# Advice to the local planning authority

<b>To LPA</b>	Kirklees
<b>LPA planning ref no</b>	2025/91221
<b>Our ref</b>	25-0336
<b>Site address</b>	Pearl House (Former HSBC Bank), 2 Cloth Hall Street, Huddersfield, HD1 2EG
<b>Proposal description</b>	Prior notification for change of use of floors 1-5 inclusive from commercial/business/service to 28 flats/studios (within a Conservation Area).
<b>Date on fire statement</b>	16/06/2025
<b>Date consultation received</b>	18/06/2025
<b>Date response sent</b>	09/07/2025

<b>Headline response from HSE</b>
Headline Response from HSE ( <b>'Advice to LPA' - Concern</b> )

BASEMENT FLOOR PLAN 1:50

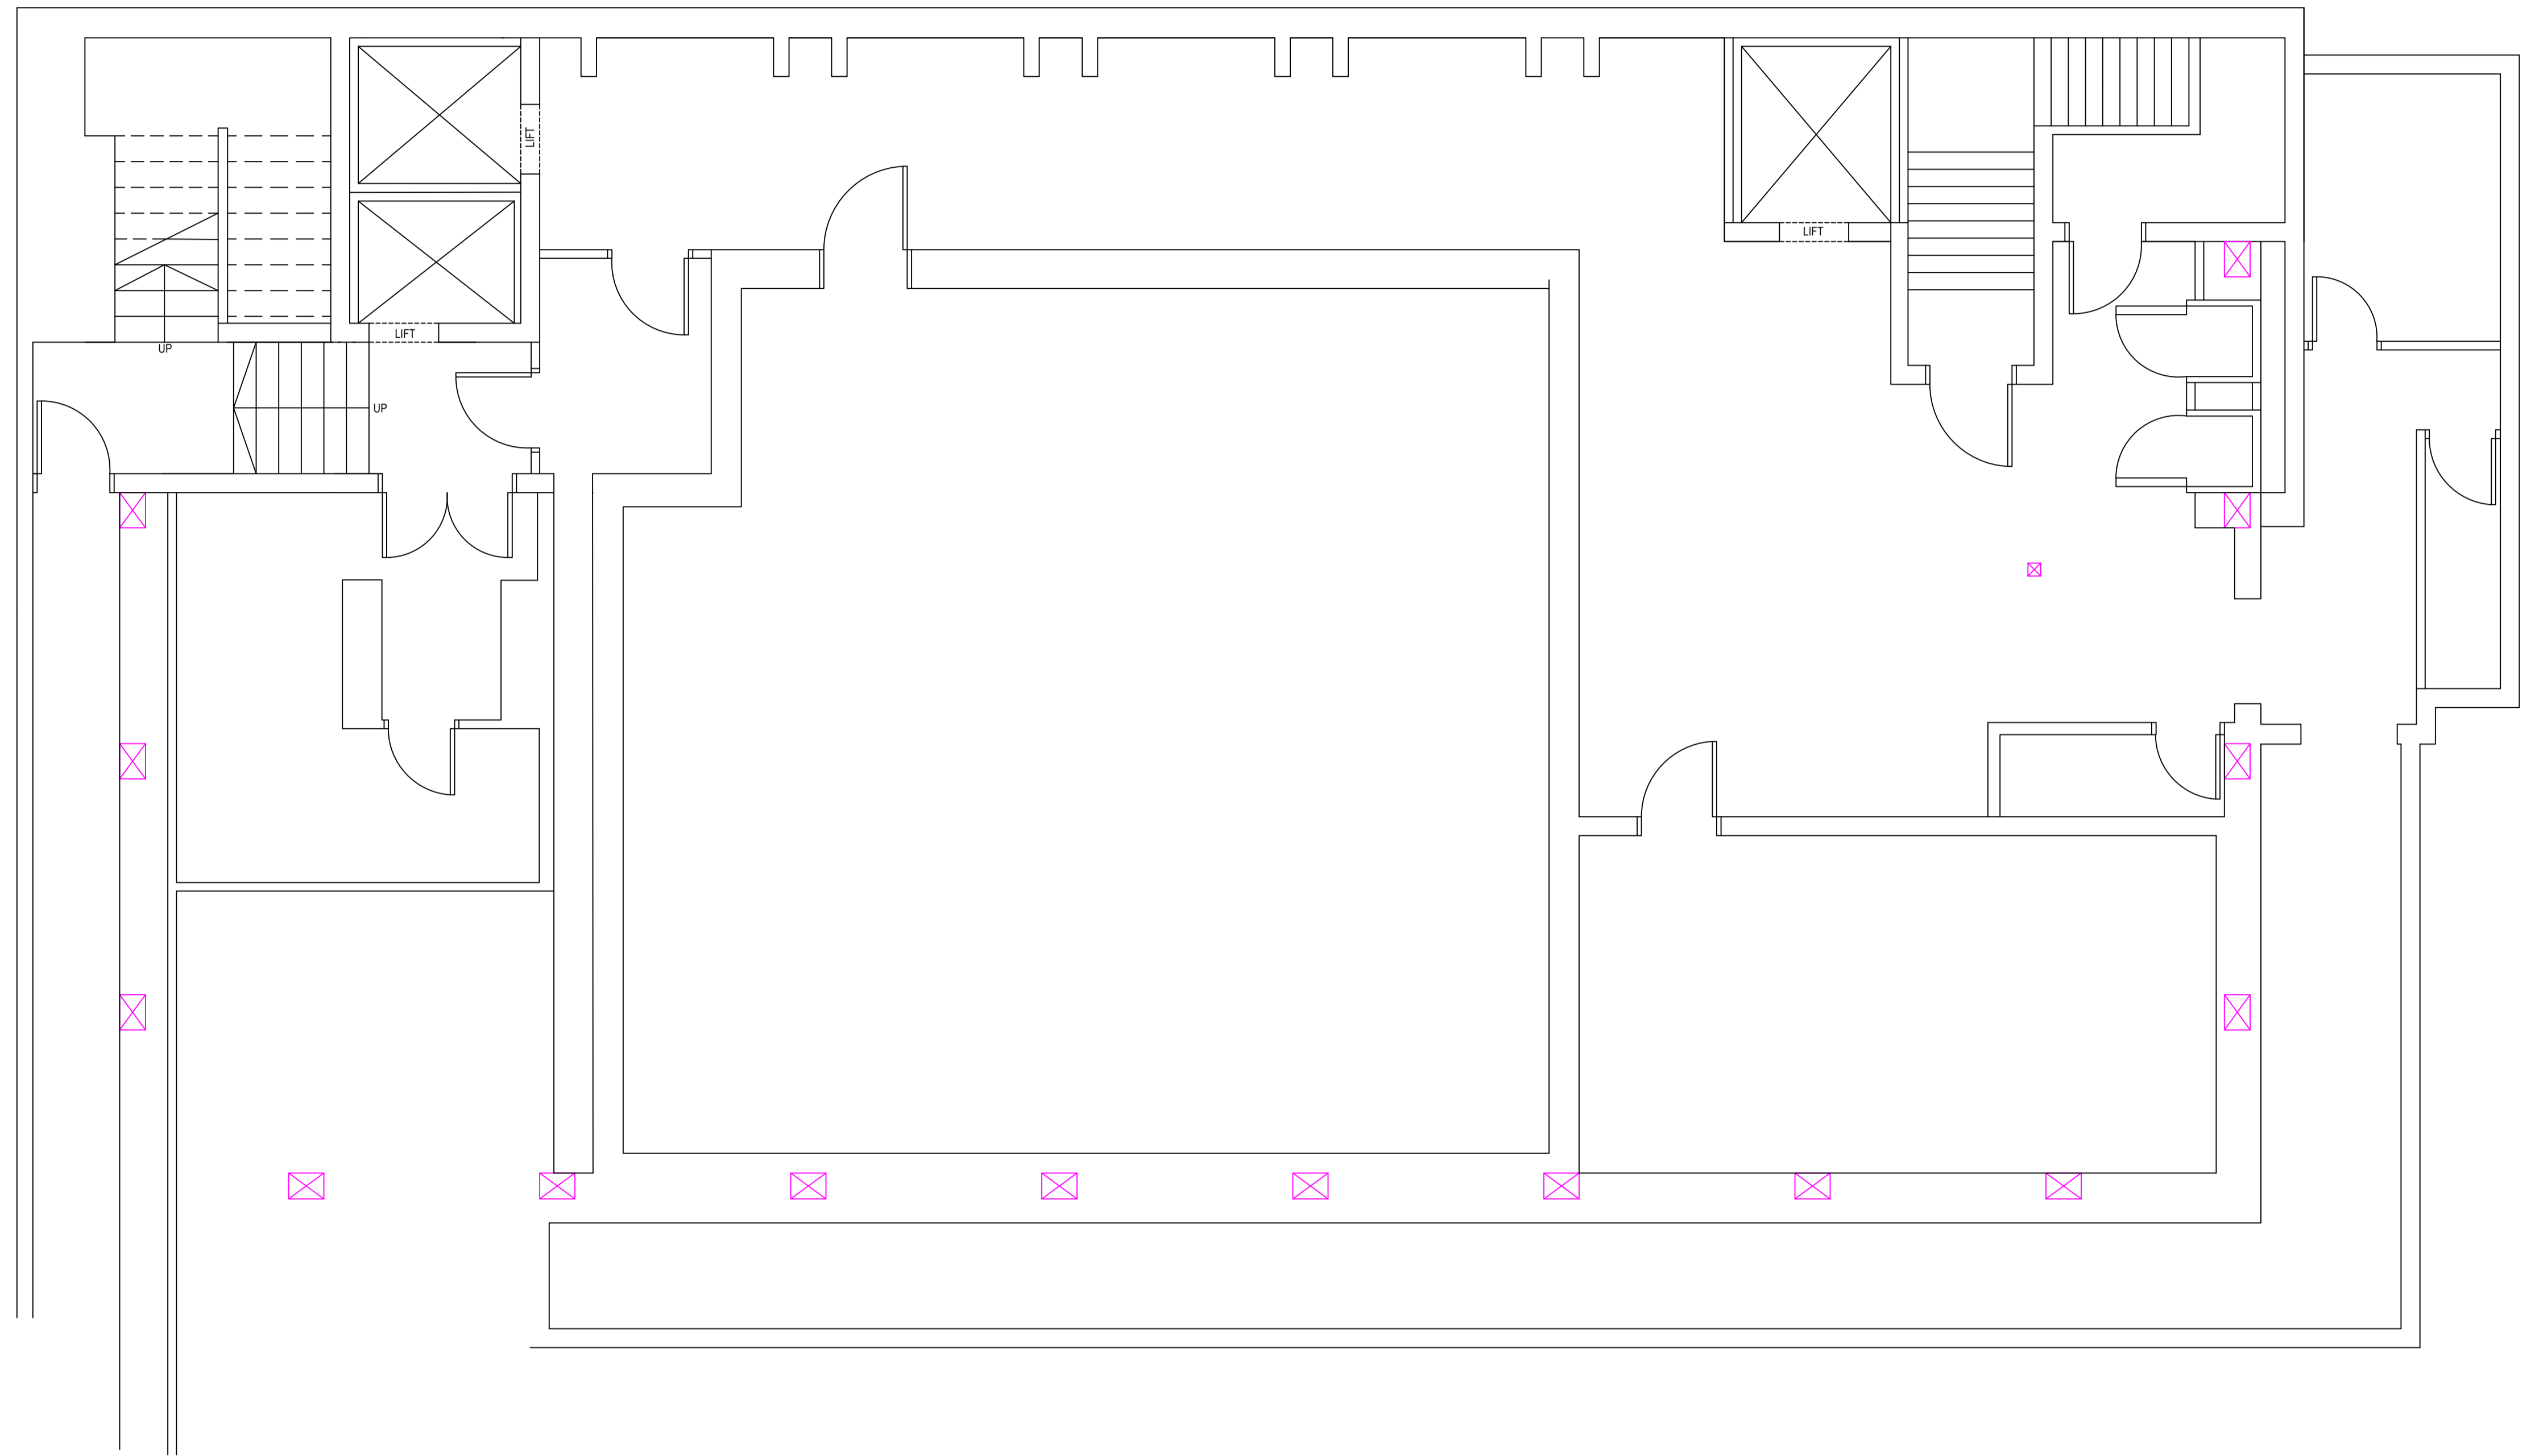
1.8. The proposed Basement and Ground Floor Plans drawings, show that the firefighting lift is located within the firefighting stair enclosure. Fire safety standards state that the firefighting lift should not be located within the stair enclosure, even if the building is being refurbished. A firefighting lift should not be installed within a stair enclosure, as it has the potential for increasing the fire load within a means of escape staircase.

1.10. The proposed Basement and Ground Floor Plans drawings, show that the Store for Ground Floor Commercial Unit / Ground Floor Commercial Unit, communicate with the firefighting shaft which serves the residential area (flats on upper floors L1 to L5). Therefore, there is a connection between the residential and the commercial areas.

2.1. The proposed Basement Floor Plan drawing shows that both stairs descend and serve the basement level. The relevant fire safety standard states that in multi-stair buildings, with a basement level, at least one stair should terminate at the ground level.
